Permit Number: 040892

This is to certify that Elc Limited Liability Company Monaghan Electric Works Inc.  
has permission to interior finish renovations and new wall construction in office  
AT 130 Middle St 029 E001001

Re: 130 Middle Street  
Fourth Floor

Job: Albin, Randall & Bennett

FILE ROOM
SCALE: 1/4"=1'-0"

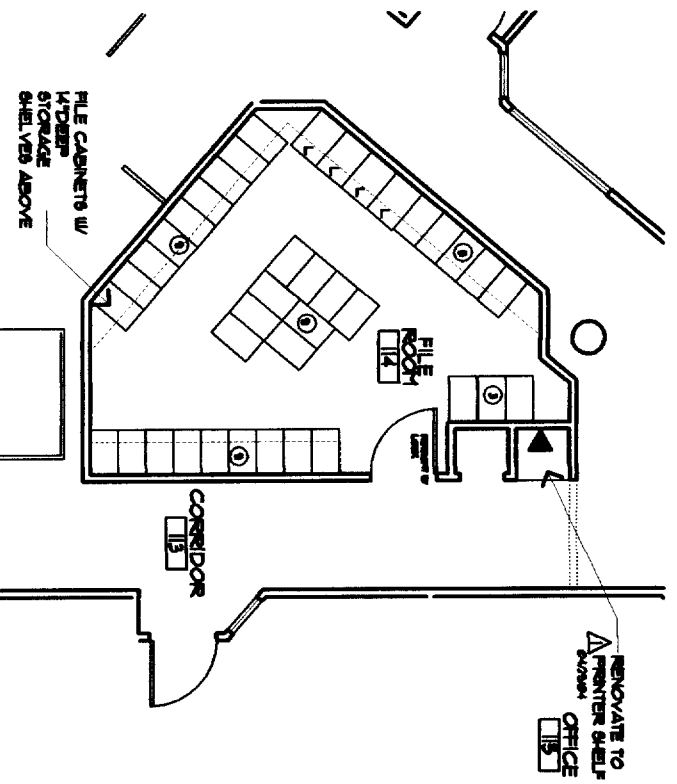
**Comments:**  
07/12/2004-mjn: ~~Need~~ Loads for File Cabinet Room

Enclosed are building plans for the above mentioned project. The proposal of the new tenant is to return two offices back to a file room. Previous architectural plans from Terrien Architects, dated October 1983 show this room as a file room.

Our new file room layout has been re-organized to align as many files as possible over an existing steel beam. The existing building floors are constructed of steel/ bar joist and concrete decking and appears to be a Type 2 protected structure. All measures without reinforcing the structure have been considered in the re-design of the tenant space.
